Heritage Council

RE: Development Consent No: NCA/3/2010, 89 George Street, Parramatta NSW 2150, Part 3A Project Application lodged with the Department of Planning for the construction of a commercial/retail development

RE: REQUEST FOR PROVISION OF DETAILS OF KEY ISSUES AND ASSESSMENT REQUIREMENTS - MAJOR PROJECT 09_0128 FOR THE CONSTRUCTION OF A COMMERCIAL/RETAIL DEVELOPMENT, 89 GEORGE STREET, PARRAMATTA

URBAN DESIGN STRATEGY

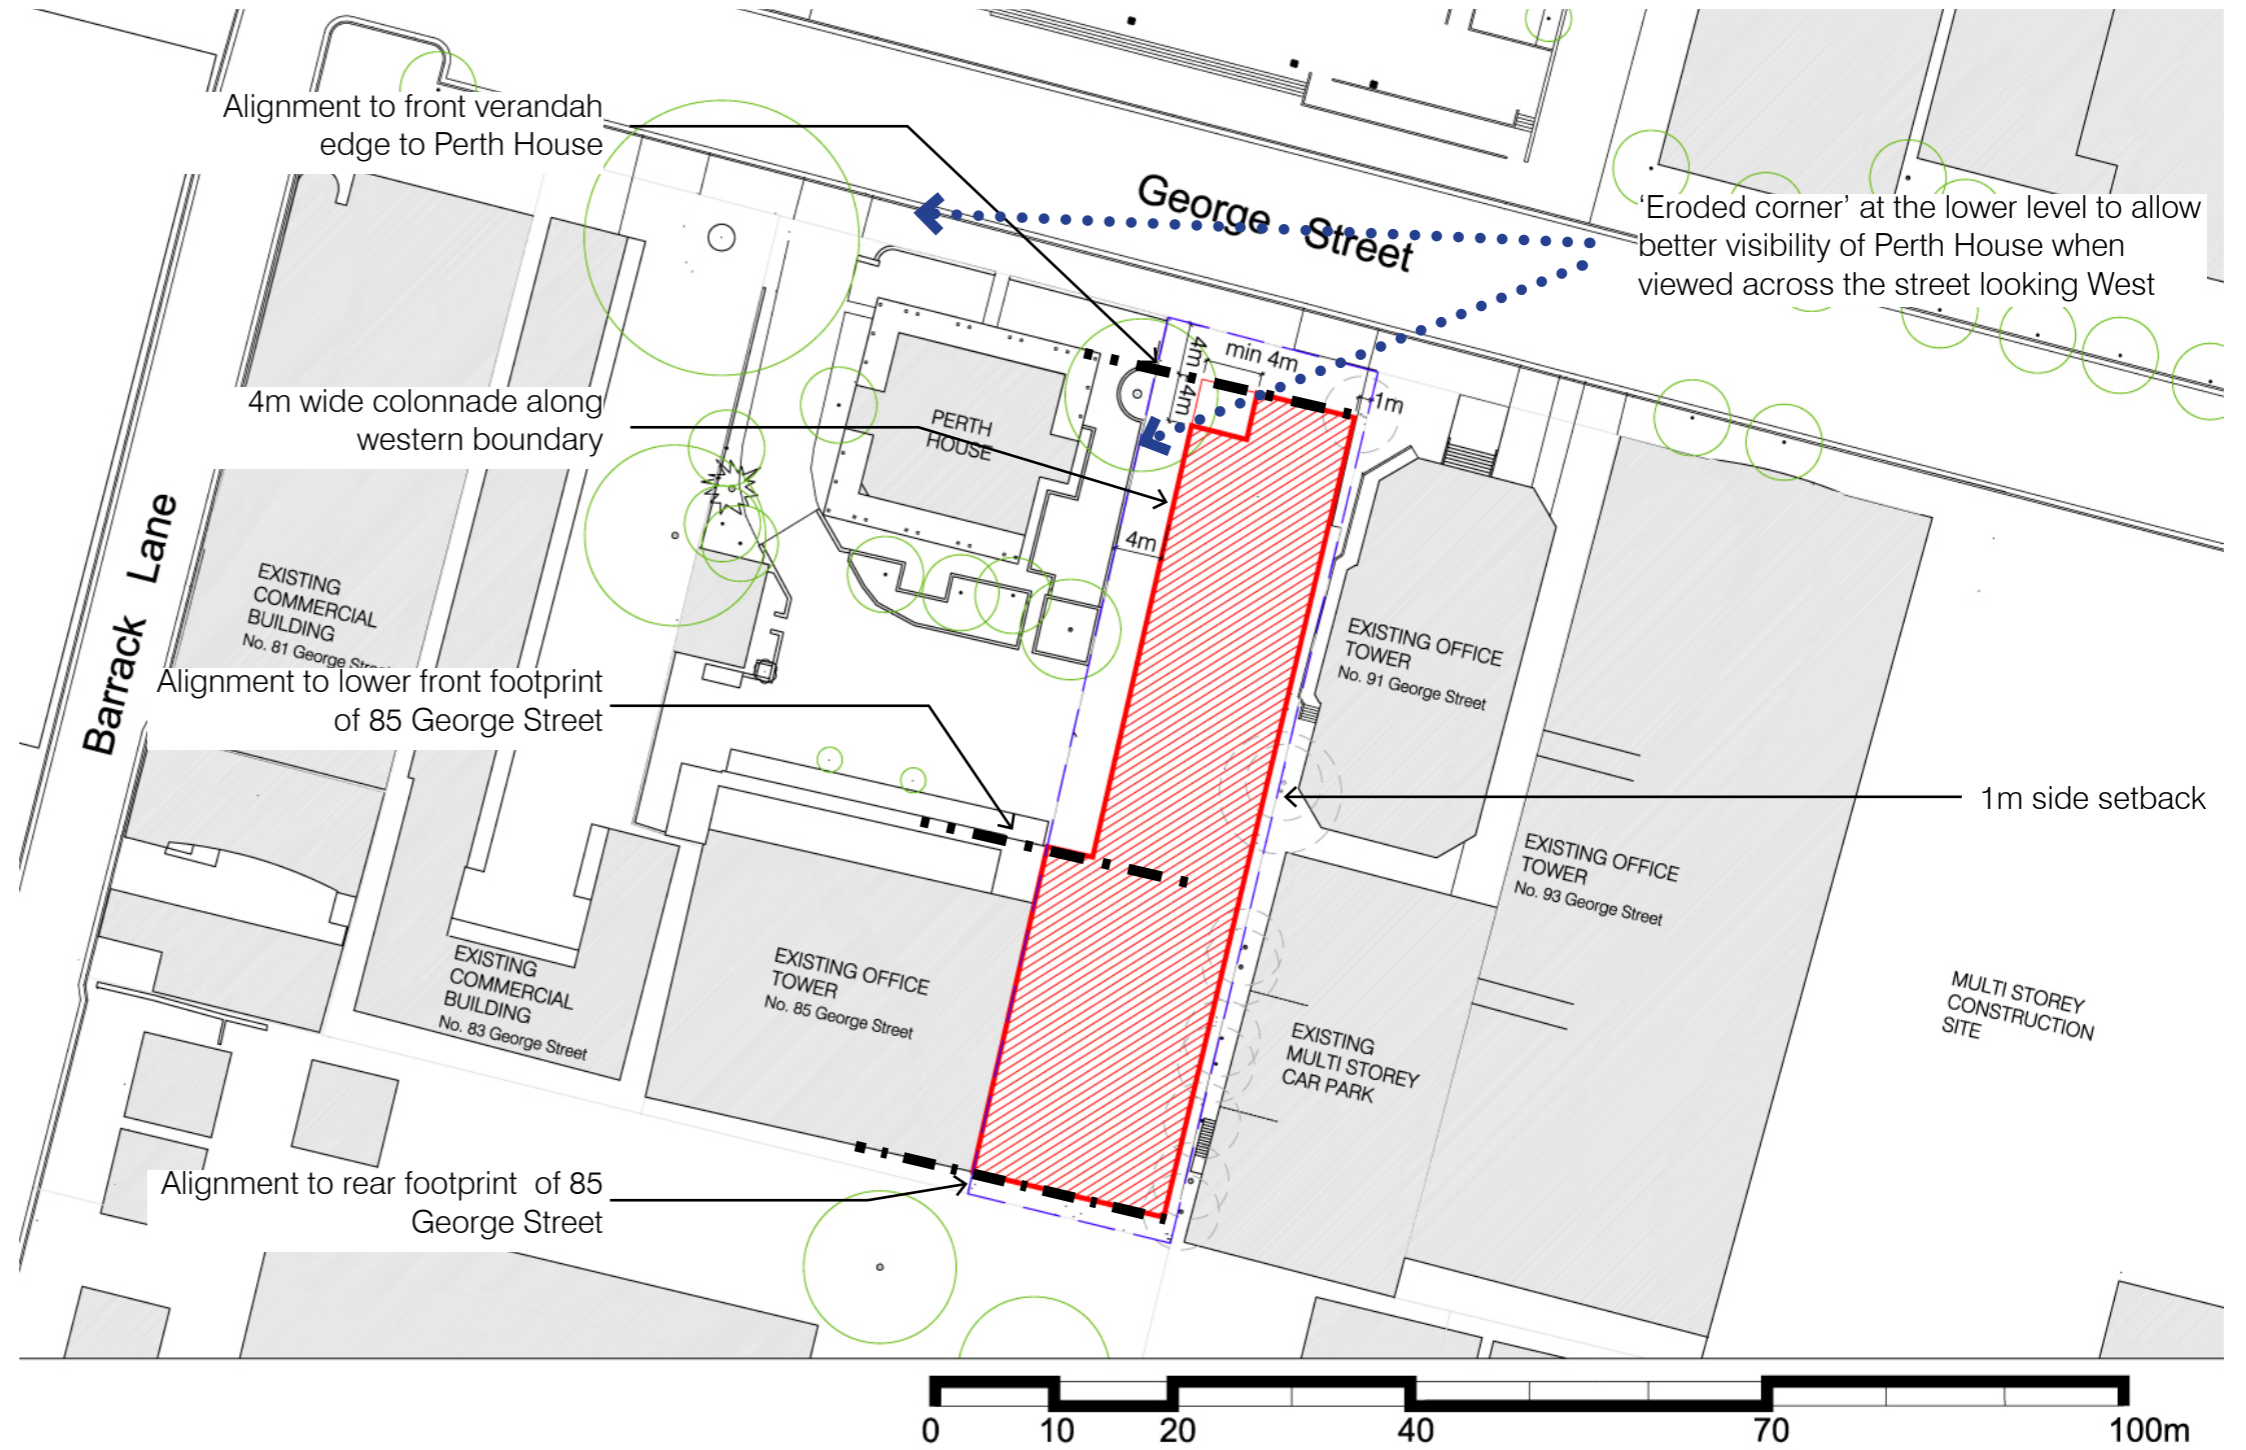
Although the proposed building has been designed to address some of the urban design issues associated with the adjacent historically significant section of George Street, these measures are not considered adequate enough to mitigate the impacts on the setting of Perth House and its views from along George Street. The Statement of Heritage Impact states that heritage issues raised during early consultation have been integrated and mitigated in the concept design. It is however noted that the final application in terms of the building design is similar to the previous one that was referred to the Heritage Branch in 2009, and the concerns raised by the Heritage Council remain unaddressed.

In light of above, the Heritage Branch considers that the Project Application in its current form will have a detrimental impact on the setting of Perth House and its views from along George Street. The building design requires major amendments in line with the Heritage Council's advice to mitigate these impacts.

1. The building design should be amended to take into consideration:
 - a) Additional setback to the new building so that the views to Perth House from George Street are not unduly impacted;
 - b) Reduction in the height of the new building at the George Street frontage where it is adjacent to Perth House and stepping the building height upwards towards the rear so as not to unduly impact on the setting of Perth House;
 - c) Increased transparency to the front portion of the building so that the Perth House can be viewed through the building; and

- d) Further setback to the building and its basement from Perth House so that adjacent trees are not unduly impacted.
2. Where archaeological relics are unexpectedly discovered during excavation, work must cease in the affected area and the Heritage Branch must be notified on writing in accordance with Section 146 of the Heritage Act, 1977.
